**Planning Application Reference No.:** 3/2026/0247

**Address of Development:** Spout Farm, Preston Road, Longridge, PR3 3BE

**Re: Permission in Principle application – Spout Farm, Longridge, PR3 3BE (up to 9 dwellings)**

Spout Farm

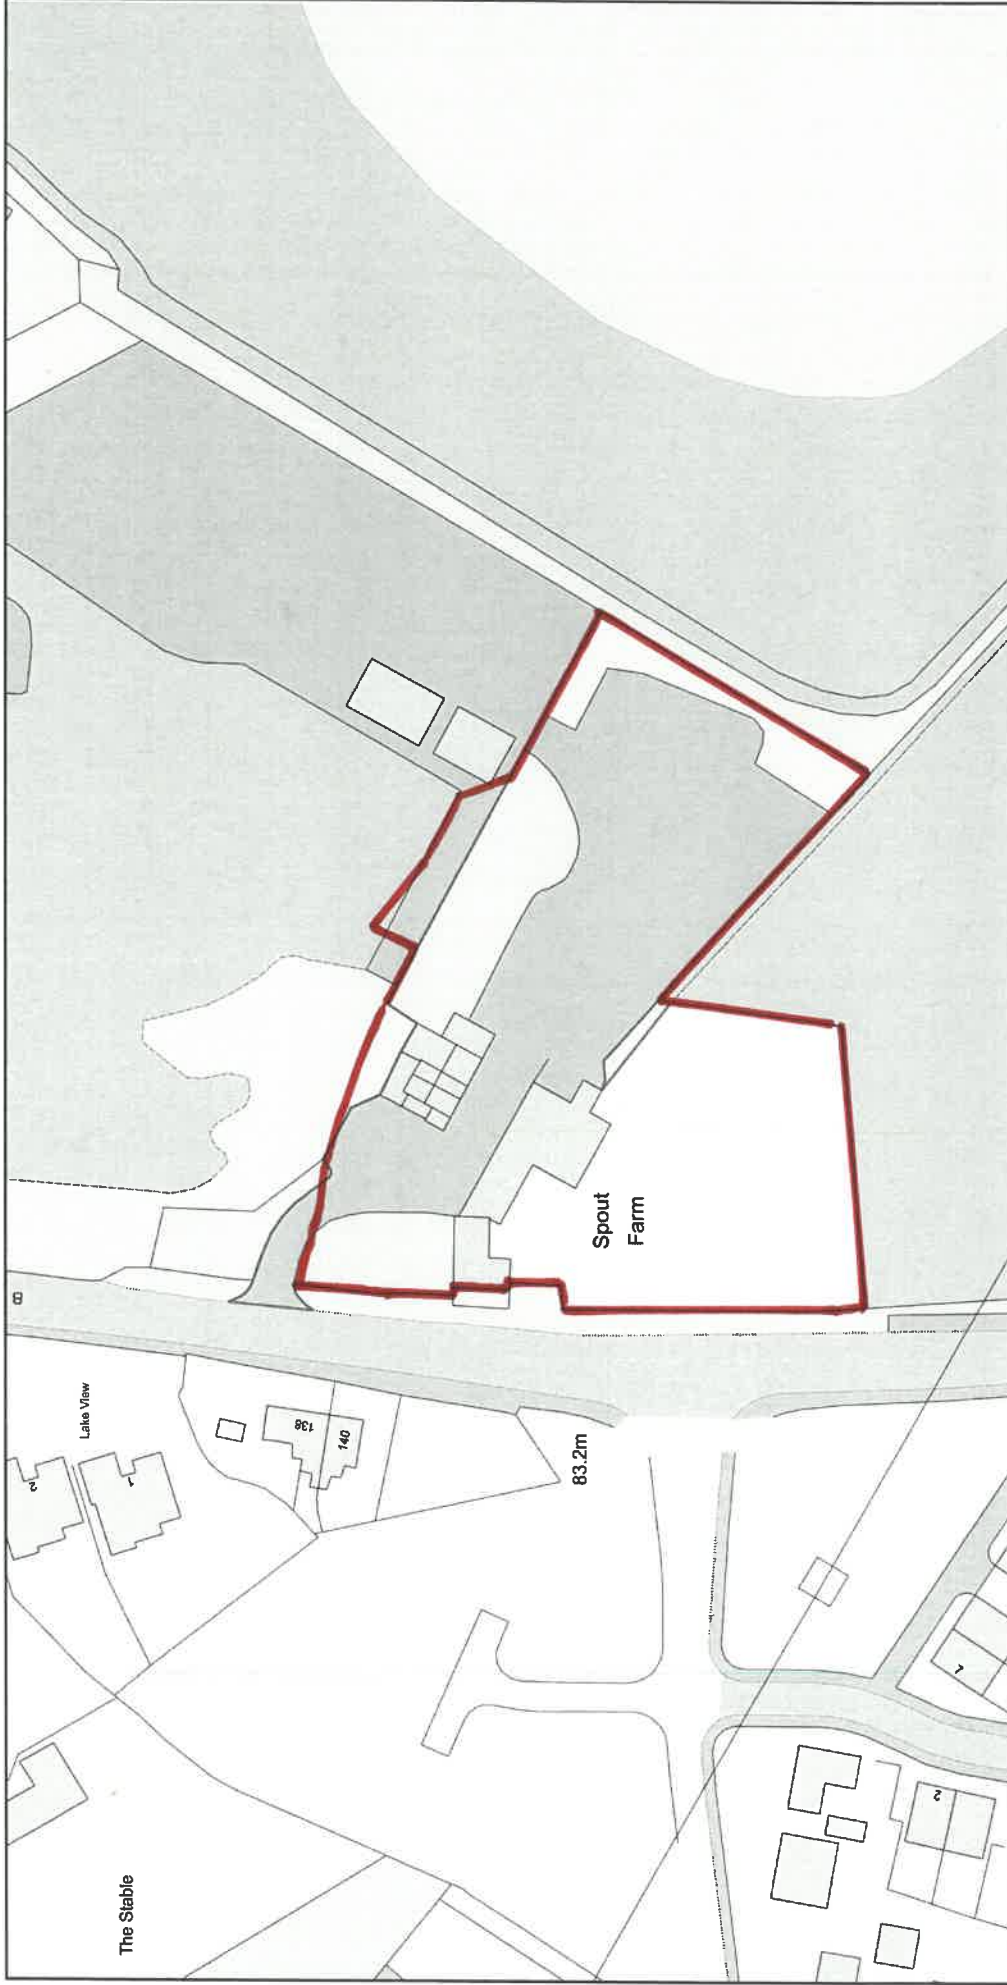
The red line outline in the PWA Planning Application is incorrect. Figure 1 shows an embellished red line that grabs more land than officially belongs to Spout Farm. Land registry document LAN242913 shows the correct boundary. The one in the application encroaches on the public open space (POS) owned by the Sandpipers Development, and also on land and gardens owned by numbers [REDACTED] Spout Lane, [REDACTED] we specifically wanted that [REDACTED] [REDACTED], and with the property being in a conservation area which was very important to us, we knew there would be wildlife frequenting the space and were told it would be landscaped. Our purchase land registry documents reflect this arrangement, as do other Spout Lane residents.

One objection to this application, namely (i) the site boundary mentioned in application 03/2026/0247 contradicts the Land Registry title LAN242913. There is an overlap and probably results from the applicant's insistence that the land belongs to him and not Create Homes even though he agreed to an independent surveyor to look at the site boundary. He did not like their findings and still does not agree the boundary. This probably is why the roads and sewers have not been made up and adopted. I believe the applicant is one of the reasons that Create Homes are no longer active and are trying to wind up the company.

The red line boundary submitted with the application conflicts with Land Registry title LAN242913 and includes land not within the applicant's control, specifically land forming part of the Sandpipers' development.

The Planning Statement (5.1.3) refers to the application site as measuring approximately 0.69 hectares which is clearly wrong when based upon incorrect boundaries.

The obvious main area of difference is shown by the red circles. The yellow highlighted section on both plans shows the location of a short access road which serves the two properties within the blue circle.

If the applicant's purported boundary in that location was right (which it is not, as demonstrated by the Land Registry plan), those two homeowners would have no means of accessing their properties, as the access road would be within the applicant's land and would most likely be blocked off by the applicant.
